KINCH SUBDIVISION

PCD FILING NO. MS-204

ENGINEERING RECORD DRAWINGS

PLAN & PROFILE
KINCH COURT

SHEET: PP1

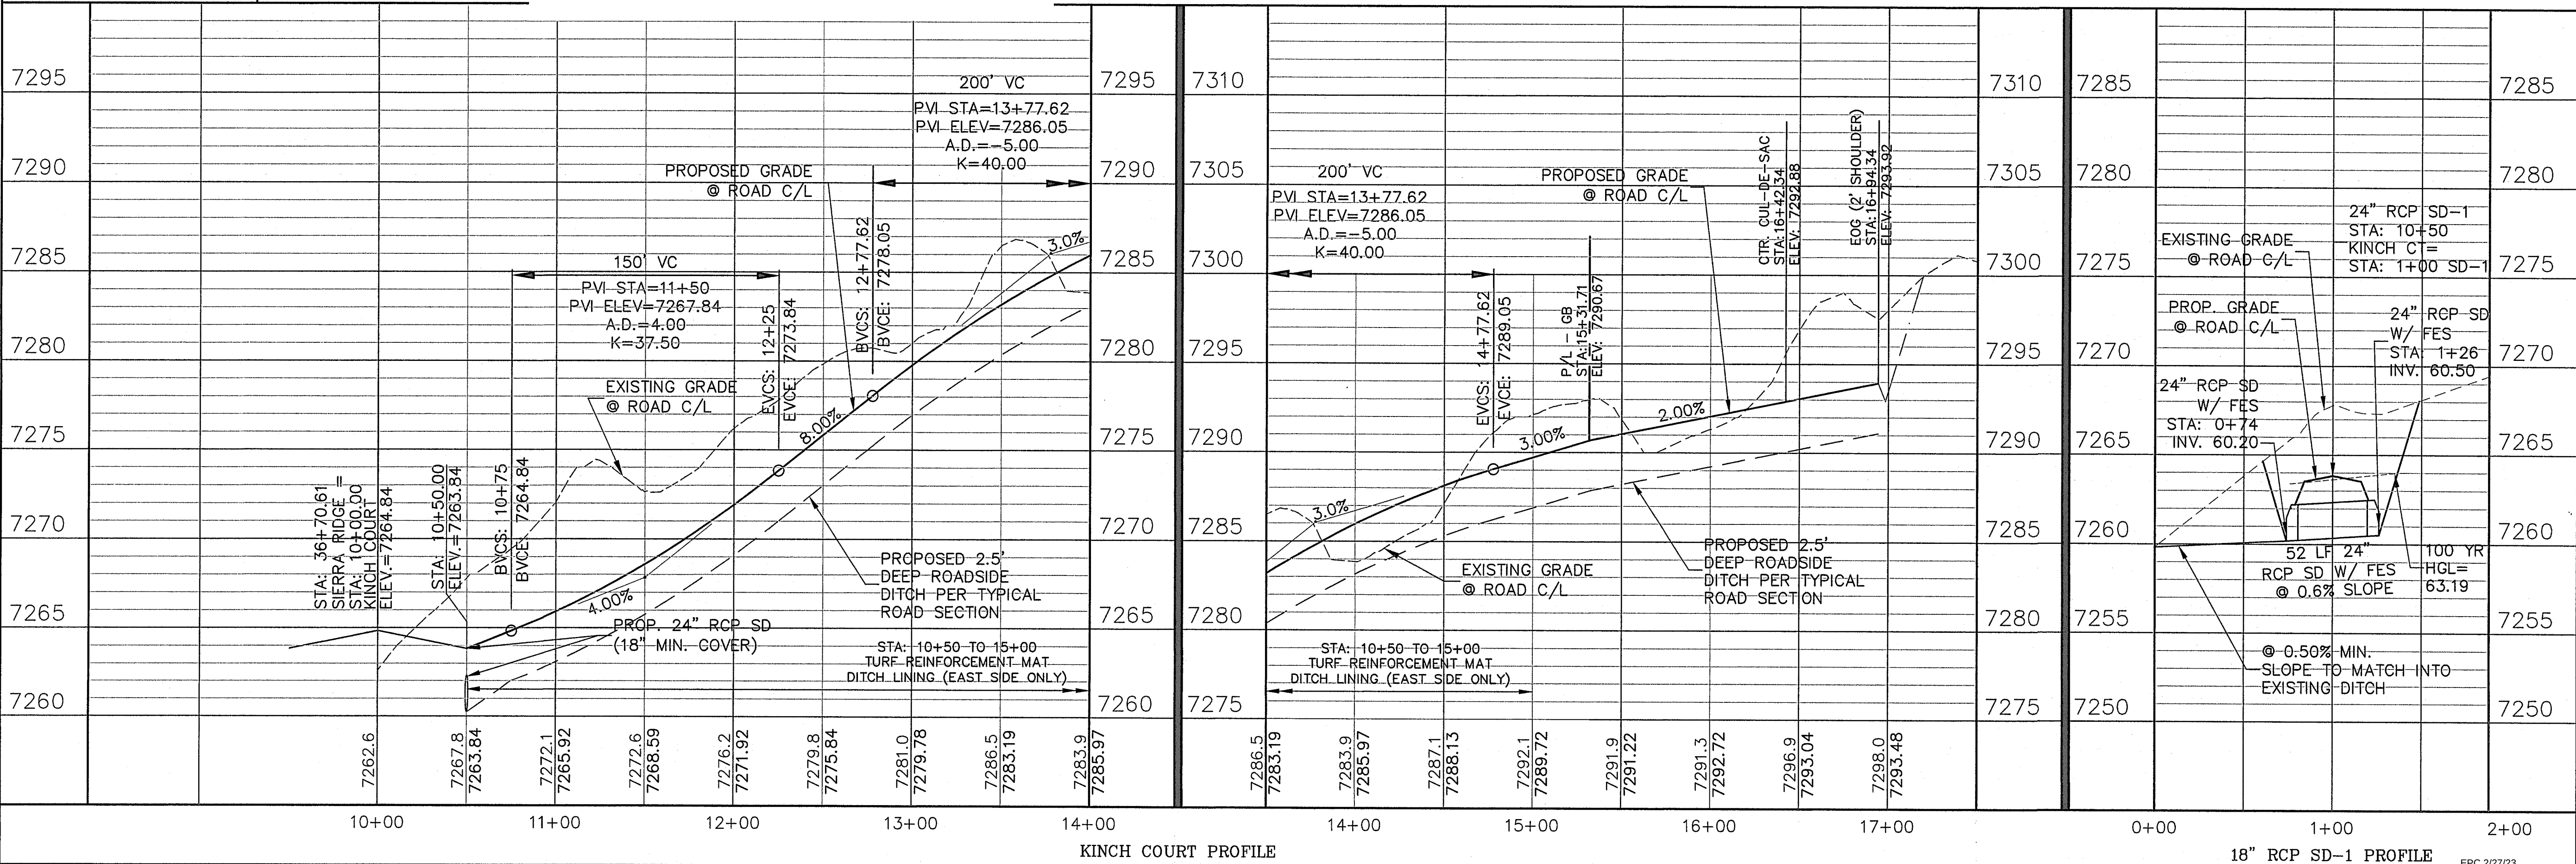
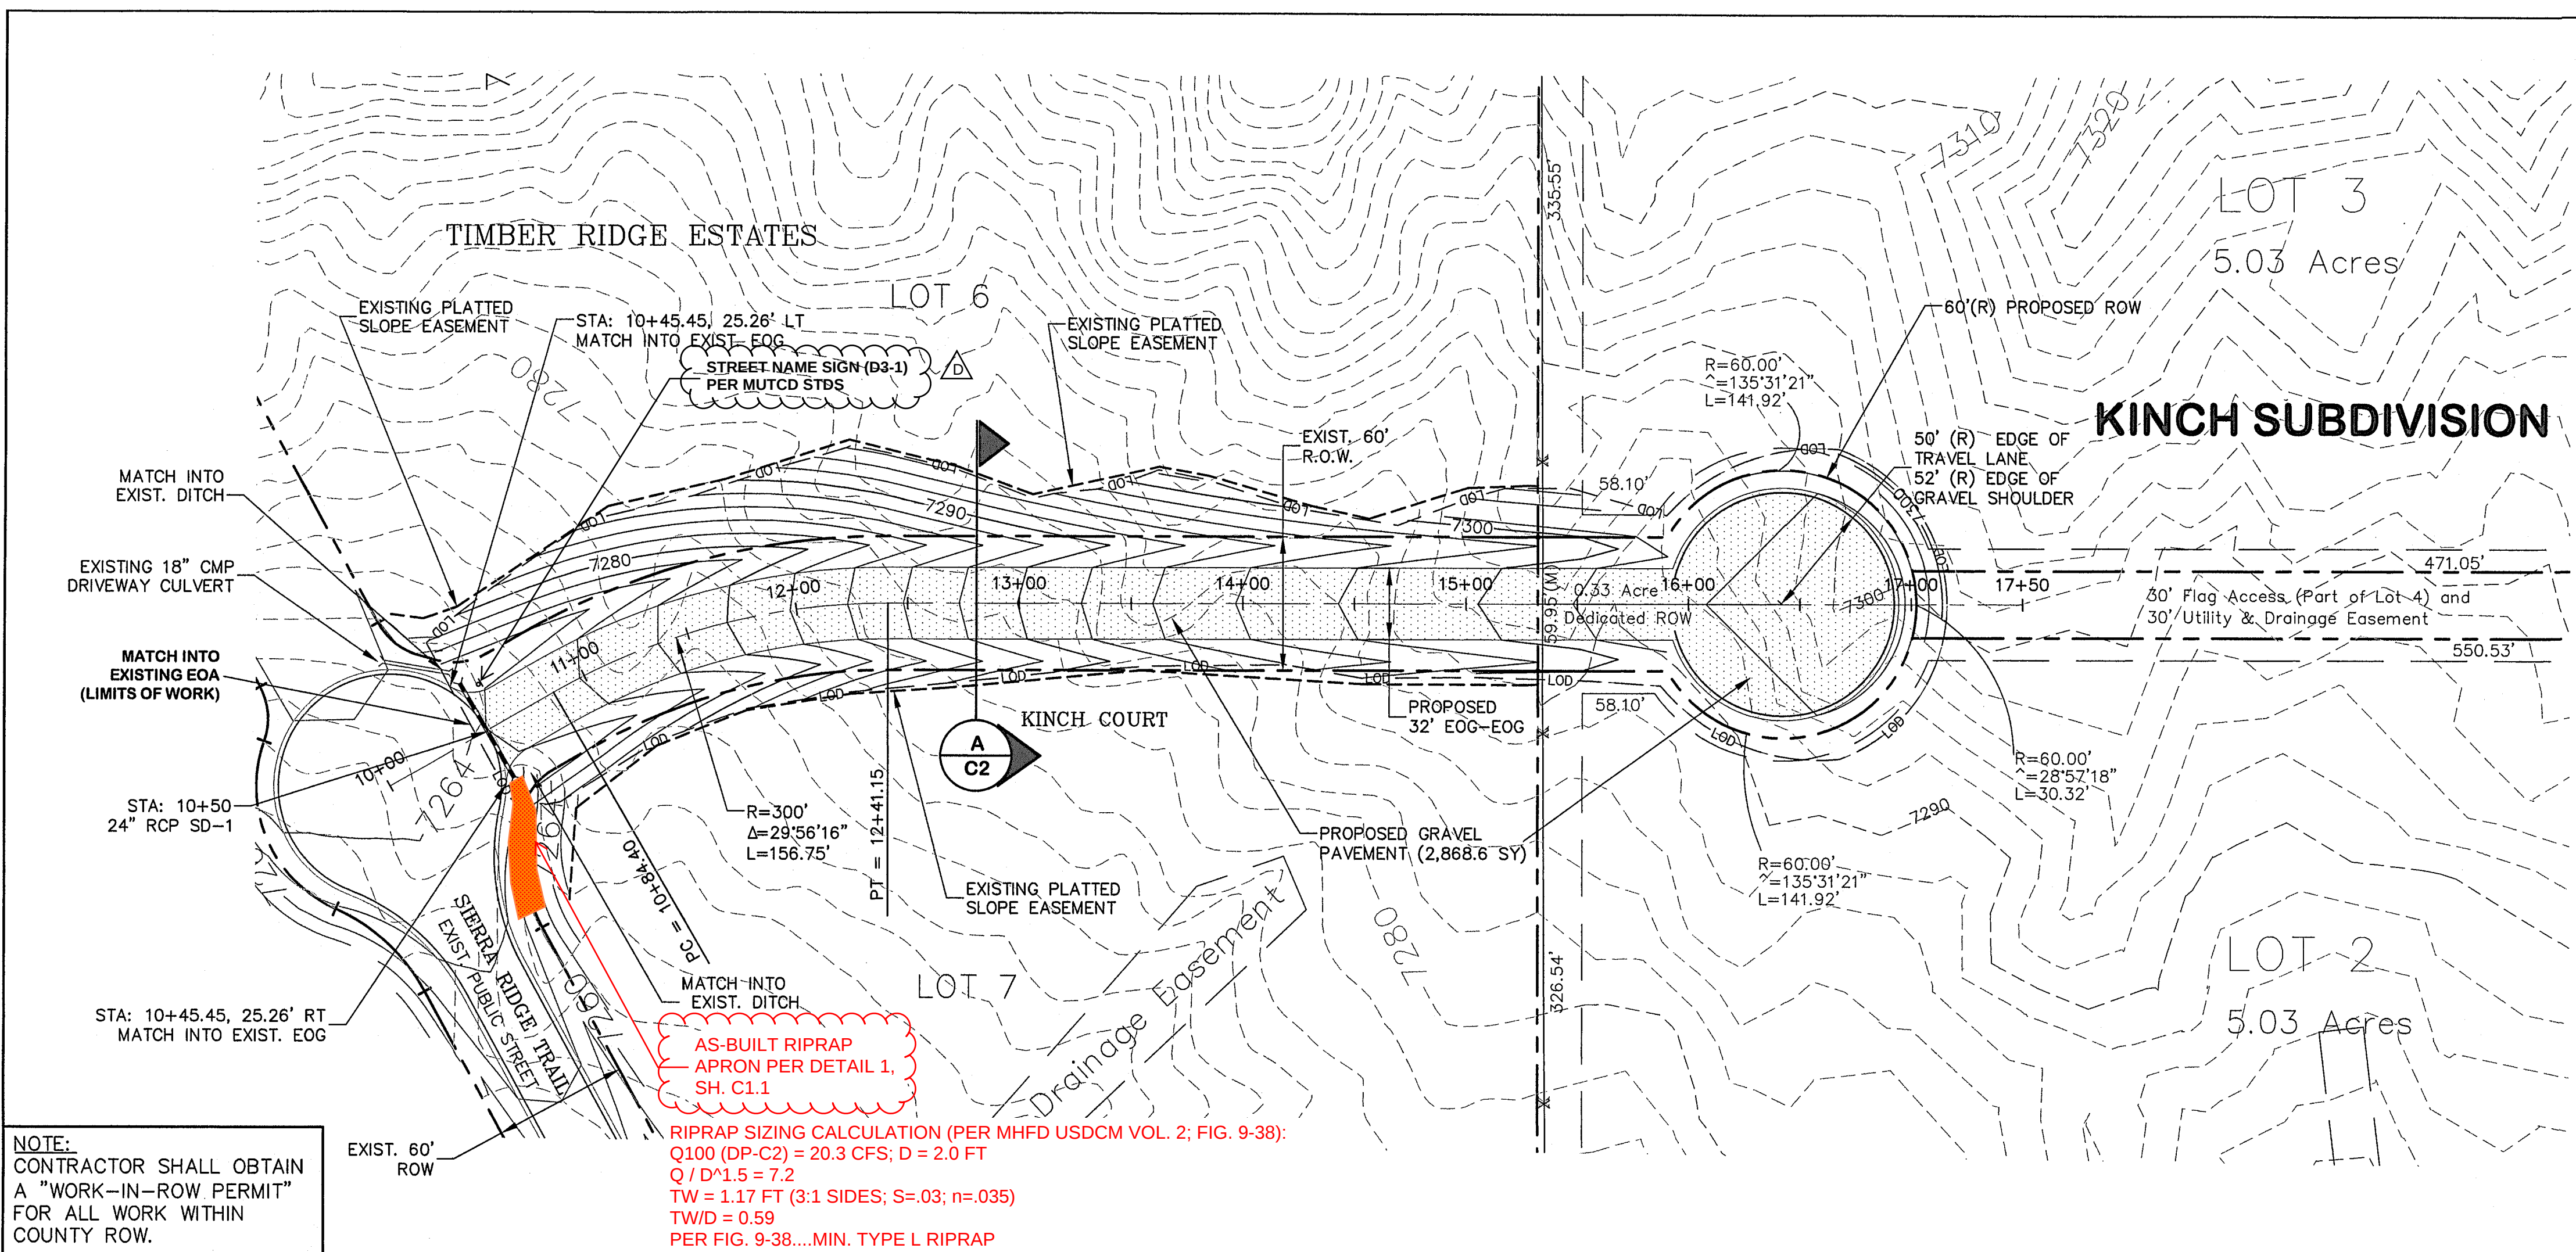
The riprap placed in the ditch along Sierra Ridge Trail is not shown in the current as-builts. Please update the as-builts to show the riprap and provide supporting calculations demonstrating that the riprap provided is sufficient to protect the ditch.
